**Re: AW/246/19/PL – Erection of 1 No. 2 Storey End of Terrace House at land adjacent to 34 Wakefield Way, Bognor Regis PO21 3RS**

Reference: - AW/246/19/PL – Erection of 1 No. 2 Storey End of Terrace House

### **OBJECTION TO THE AFOREMENTIONED APPLICATION**

Site Plan

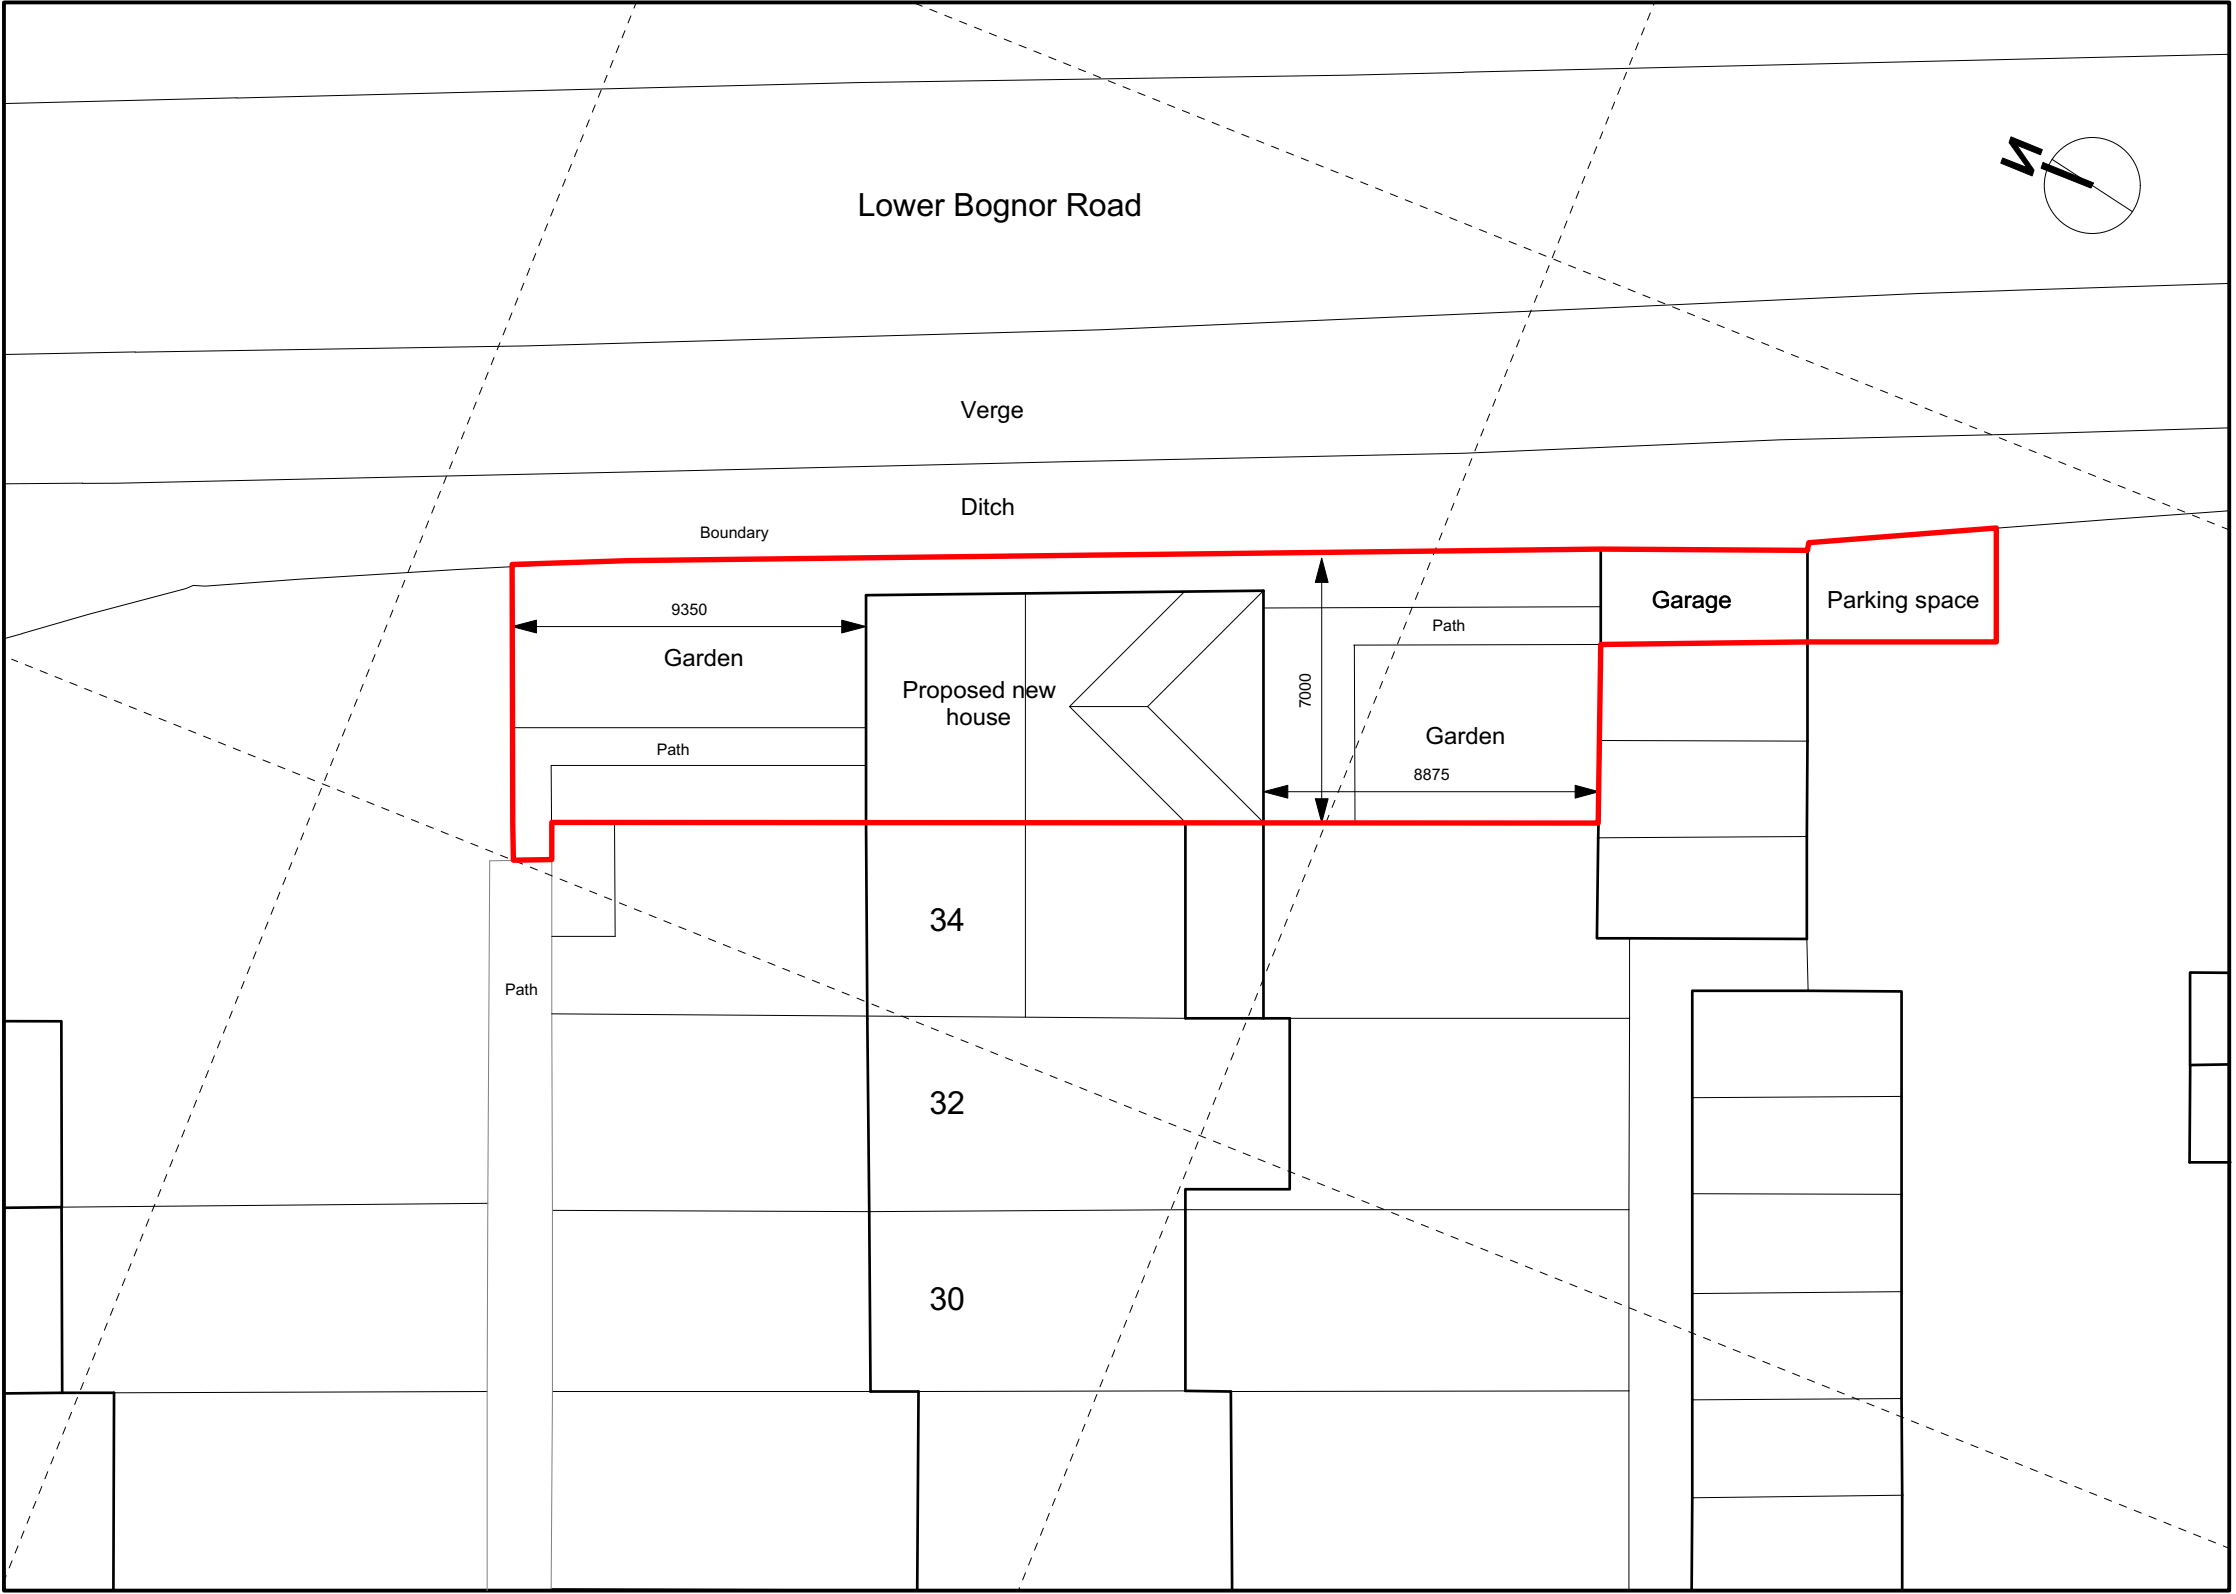
I refer specifically to IBA Drawings IBA/520/01, 02 & 03.

In paragraph 2 of the Design and Access Statement on Page 5 of the self-named document, I quote *"Parking is provided on site, with one garage space and one parking space in front of the garage"*

The first of which is a garage situated at the far end of the L/H side of the garage block. This garage is apportioned to No.34 (the existing dwelling) therefore no "additional" space has been created, it has simply been re-assigned from an existing dwelling to the proposed. This conclusion has also been noted within the WSCC Consultation.

There is also a further point to the proposed use of a garage as a parking space within this application. As per the WSCC Consultation, the garage in question is only 2.5m wide and 5.5m long. This is barely big enough for a standard size family vehicle. However, the Design and Access Statement submitted makes note that the garage will also be the "Bin Store" for three wheeled refuse bins along with space for two bicycles. I do not see how a car, three wheelie bins and two bicycles will fit into this garage. The floor space is simply not enough.

Secondly the area of hard standing in front of the garage cannot be assigned to any one property as it does not fall within the ownership boundaries of the existing dwelling.
